From: Alastair Dineen [REDACTED]
Sent: 29 November 2018 07:02
To: Simon Davis
Subject: RE: 251 Pagham Road

ARUN DISTRICT COUNCIL P/1/18/DOC

drawing title	Landscape General Arrangement (East)				
drawing no.	1896-TF-00-00-DR-L-1002				P03
scale	1:250 @ A1	date	28.09.17	drawn by	AC
				checked by	AC

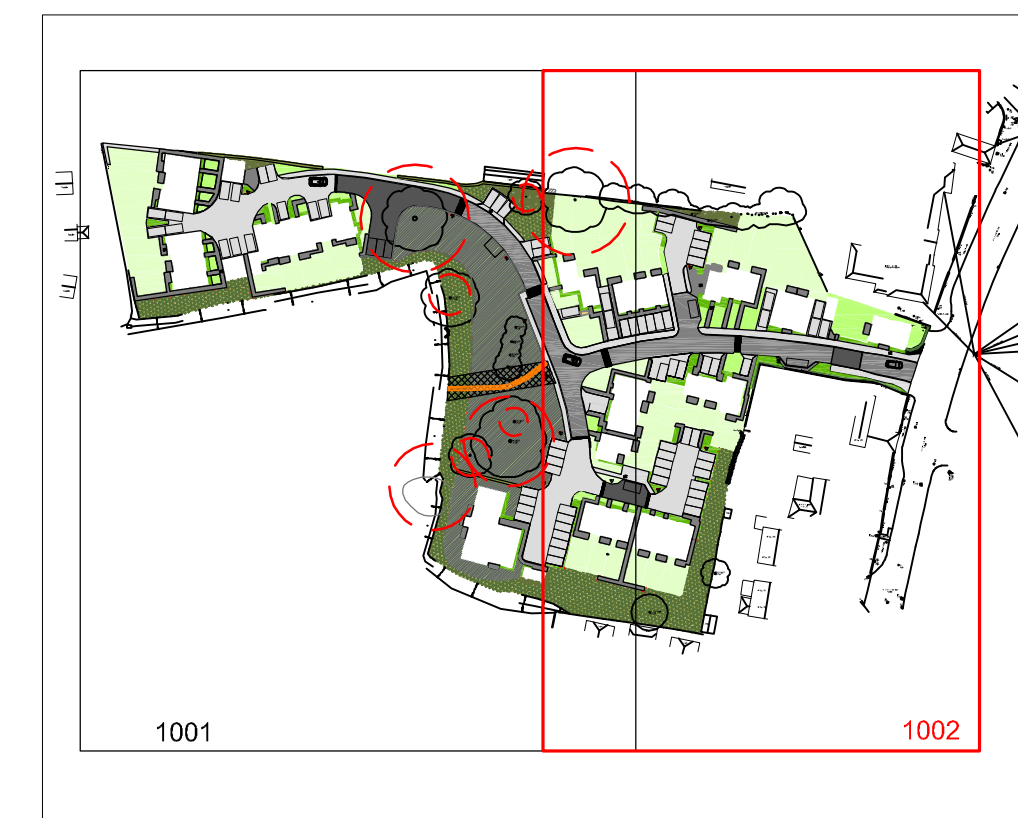
I am not sure of the specific letter you refer to but I am aware of the issues Mill Farm residents have - as reported in the press. I wonder whether you are able to propose additional landscaping along this boundary as the current landscaping scheme shows no planting at the rears of the gardens for plot 13-16?

We have already discharged your landscaping condition and as long as you implement the approved scheme there is no breach of condition. You are however, free to add additional planting and therefore, we are happy for you to just go ahead and put in this extra landscaping.
